7 Valle Gardens, Leigh, Kent, TN11 9FB

I am writing in relation to the recent planning application (23/02604/HOUSE) which has been submitted in relation to 7 Valle Gardens. We have a number of concerns in relation to this planning application which I have set out in further detail below.

Site Address: 7 Valle Gardens, Leigh, Tonbridge, TN11 9FA
Date: 13/09/2023
Title: Proposed floor and roof plans.
Drawing Number: EB0002VG
Scale: 1:100 @ A3

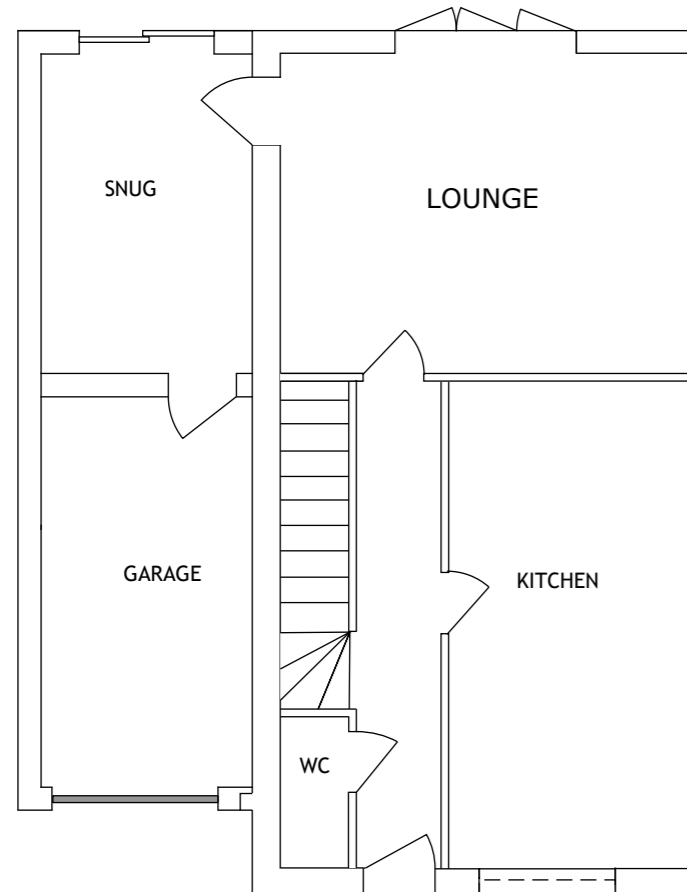
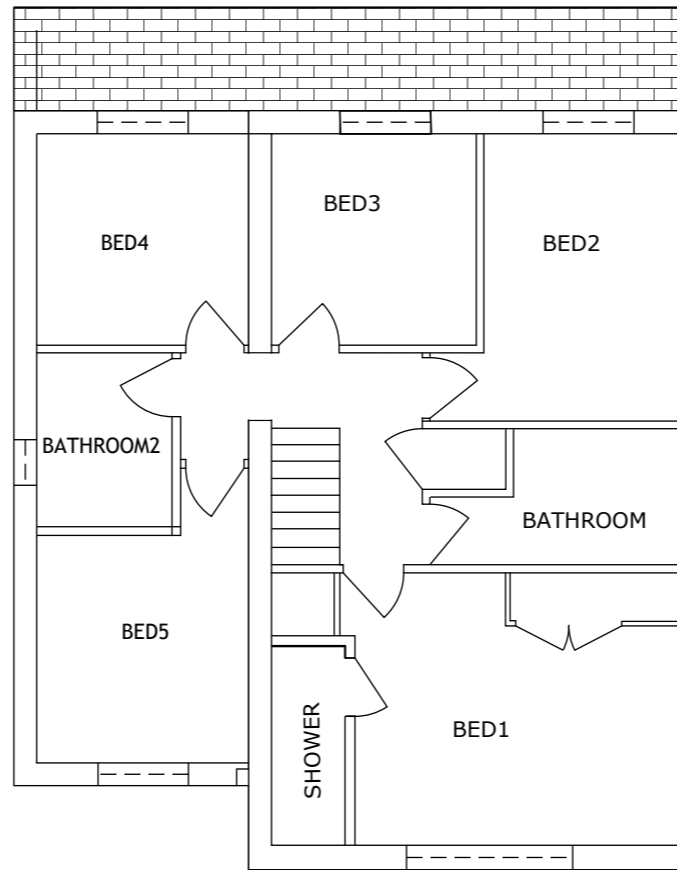
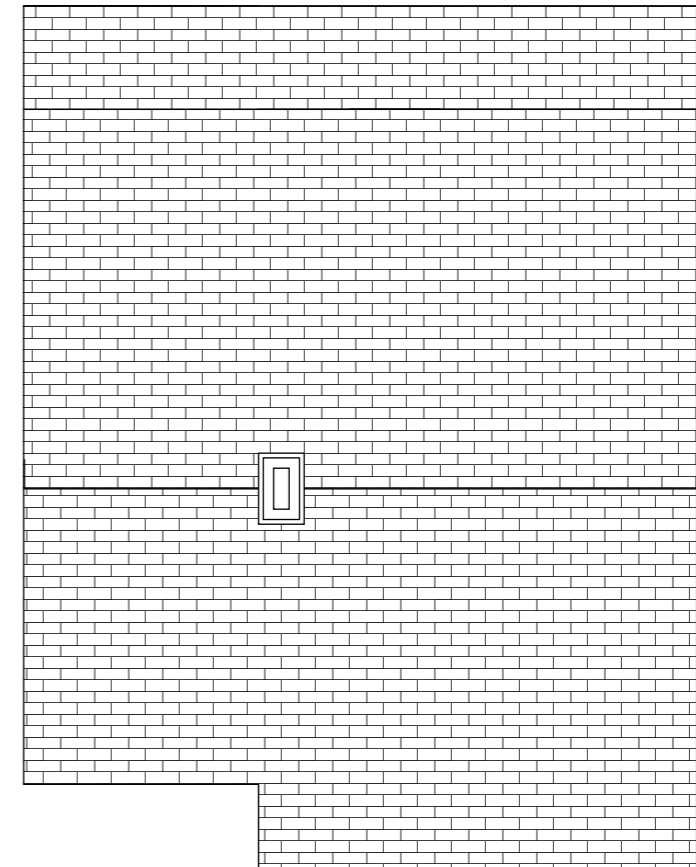
The proposed two storey extension would create a significantly larger residential dwelling with kitchen, W.C, lounge and snug at ground floor level with five bedrooms, two bathrooms and shower room at first floor level. The parking provisions would also be significantly altered removing the car port and replacing it with the snug, a garage would be erected on one of the parking spaces with one space remaining.

The KCC parking standards goes on to state (Page 5) that garages are unlikely to be used for the parking of a vehicle unless there are no alternative parking options available in the locality. As such, in suburban and rural locations, the Local Highway Authority will not count garages as formal car parking spaces. Furthermore, parking spaces in front of garages should provide space for the full length of the vehicle plus an allowance for opening of a garage door where applicable 6.0m should be provided in front of garages. The proposed site layout would only allow for a 5m parking space between the garage and Valle Gardens which would not be sufficient for a large family car that would no doubt be required for a five bedroom dwelling.

Site Address: 7 Valle Gardens, Leigh, Tonbridge, TN11 9FA
Date: 13/09/2023
Title: Proposed Elevations.
Drawing Number: EB0004VG
Scale: 1:100 @ A3

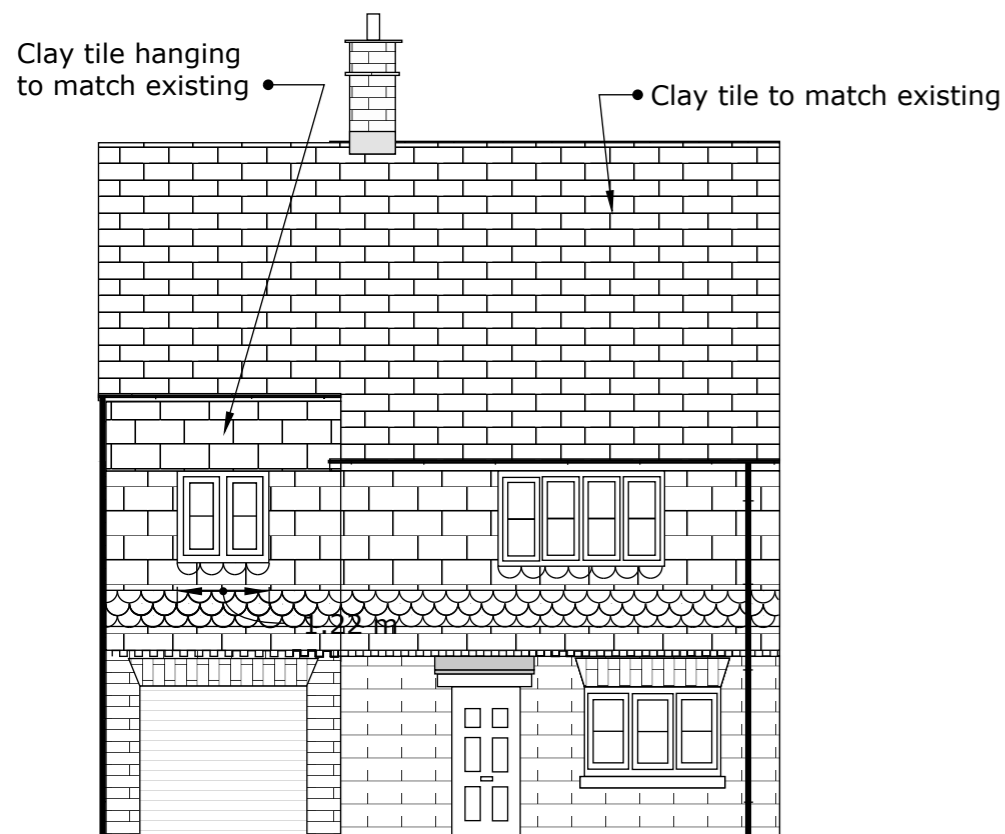
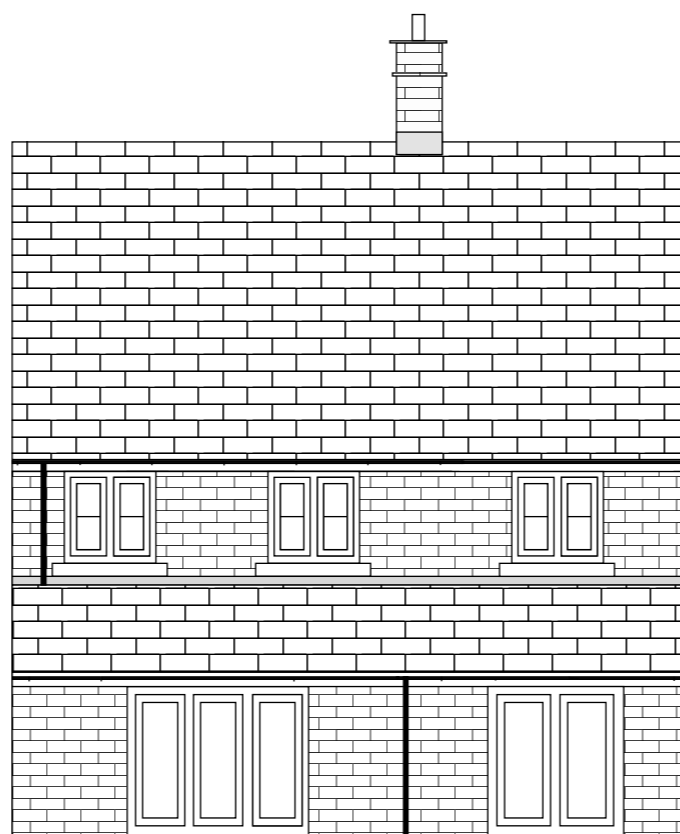
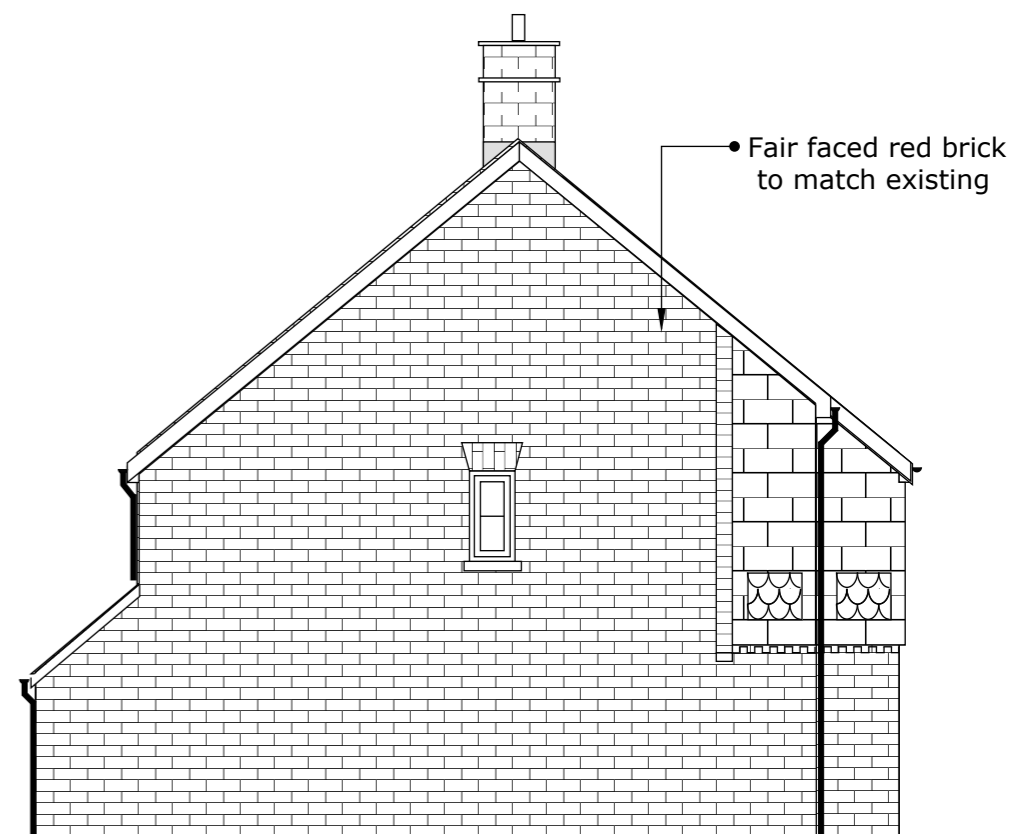
The proposed extension to 7 Valle Gardens would see the existing dwelling 142m² (including car port) expand significantly to 181.6m² (including garage) an increase in the floor area of 27.8%. A review of the Sevenoaks Allocations and Development Management Plan (2015) sets out Policies EN1 & EN2. The criteria in EN1 (a) is that a proposed development should respond to the scale, height, materials and site coverage of the area. The 27.8% increase in floor area would add significant bulk to the dwelling and would be overbearing to neighbouring properties in particular 23 Burton Avenue. The extension of the property would bring the dwelling 3m closer to the dwelling at 23 Burton Avenue eroding the visual gap between the two dwellings and causing a disruption to the spatial pattern of development on the street which was carefully considered when the site was first planned. The distance between the edge of the proposed dwelling and the boundary of 23 Burton Avenue is approx. 1.5m.

Policy EN2 as set out above clearly states that poorly designed house extensions can have direct impacts on neighbouring occupiers. The position of the garden and windows at 23 Burton Avenue mean that the extension of 7 Valle Gardens would have an overbearing impact upon the neighbouring property. It is clear that this extension has not been designed sympathetically and would lead to a loss of the existing amenity and visual intrusion on adjoining properties.
